Submission by the Community Environment Network
State Significant Development Application (SSD – 10321)

87-89 John Whiteway Drive, Gosford

Project Number	Drawing Number	Rev
19002	DA004.3	12
Coordinator : Approver	Checked : Checker	
Scale: As indicated @ A1	Date Printed: 28/05/2021 1:15:07 PM	
File Name:

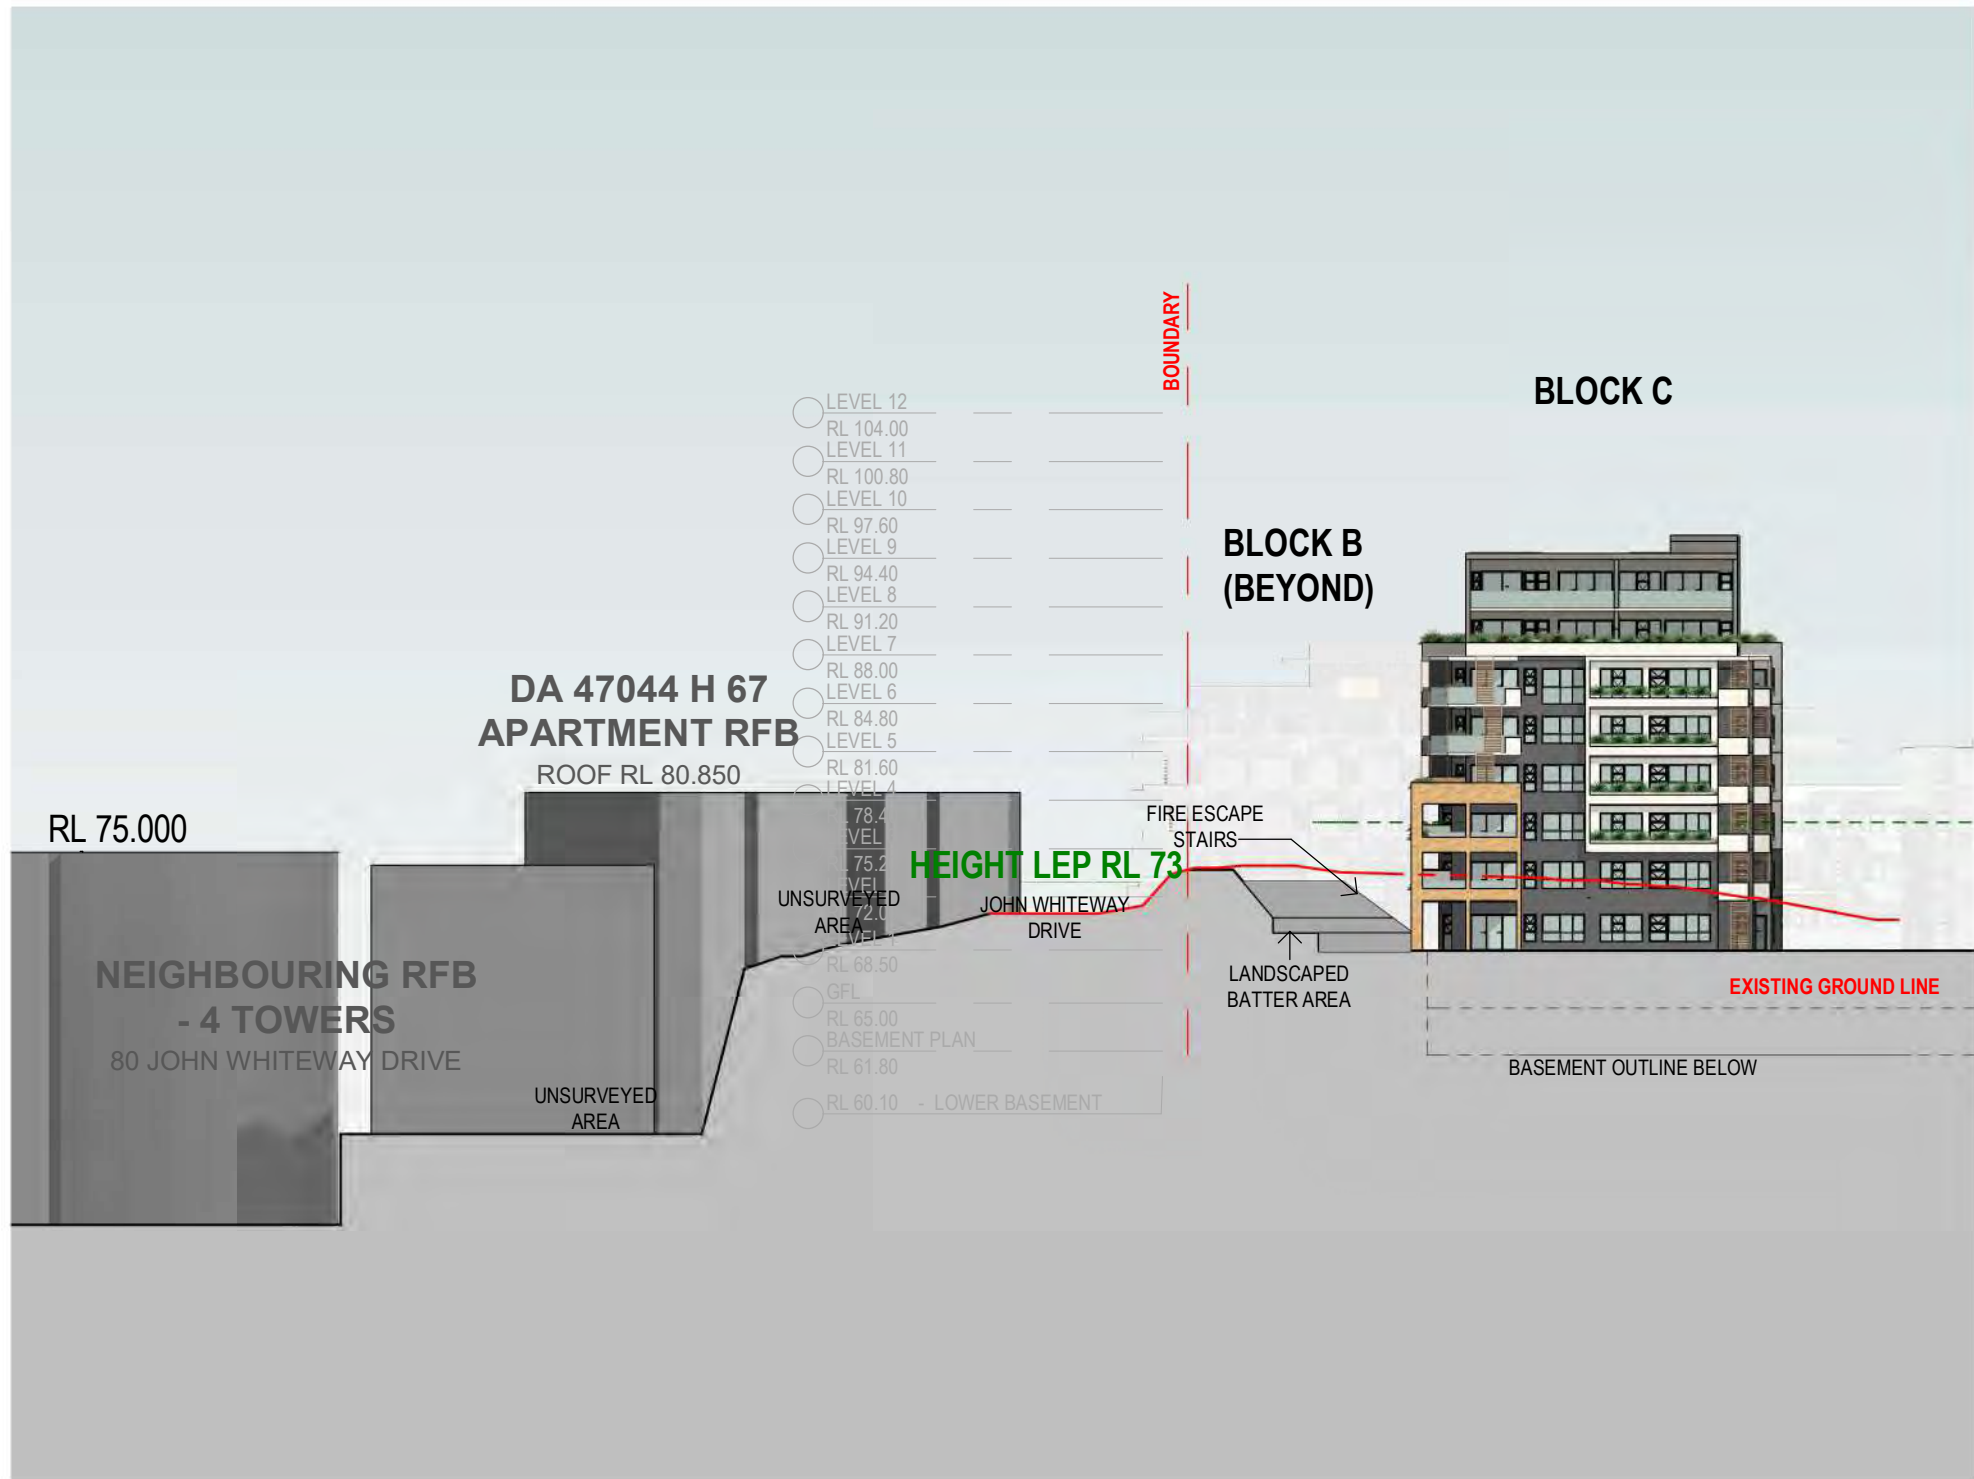
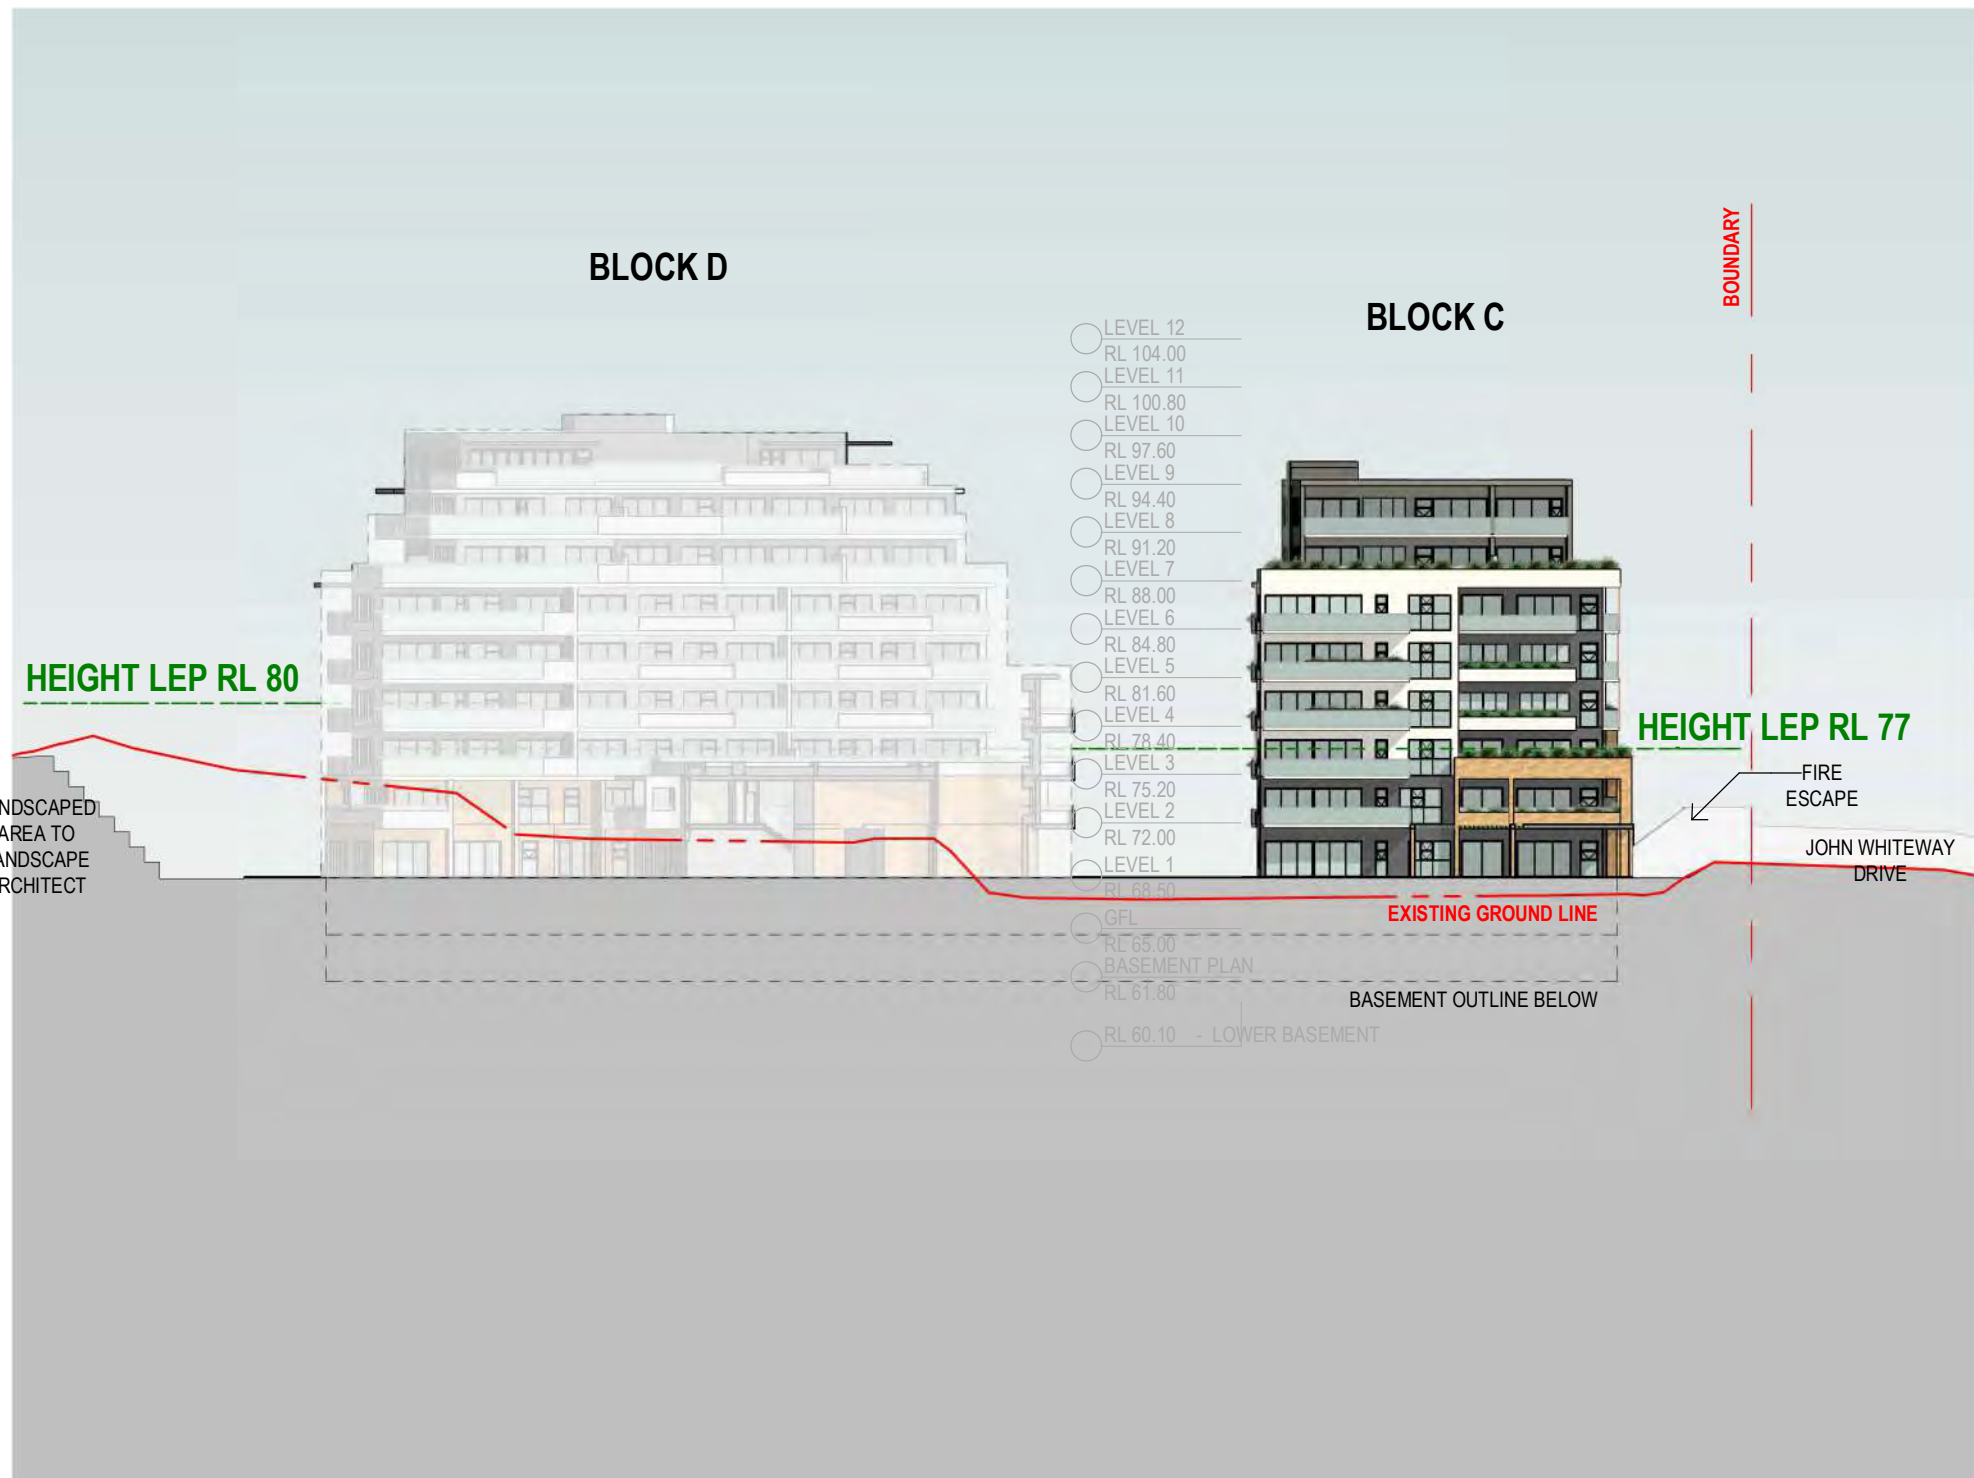
Consequently, the table demonstrates what massive increases in height are proposed by this “Clause 4.6 Variation Request”, in particular for Buildings C and D. Both buildings are proposed with heights exceeding the height limit by more than 300% of the permissible building height.

Despite the shortcomings in the Visual Impact report, it is concluded that Buildings C and D would be visible from most, if not all, viewpoints to the west and south-west of the site. It is likely that they will be on the ridgeline in those views, especially when the APZ is implemented.
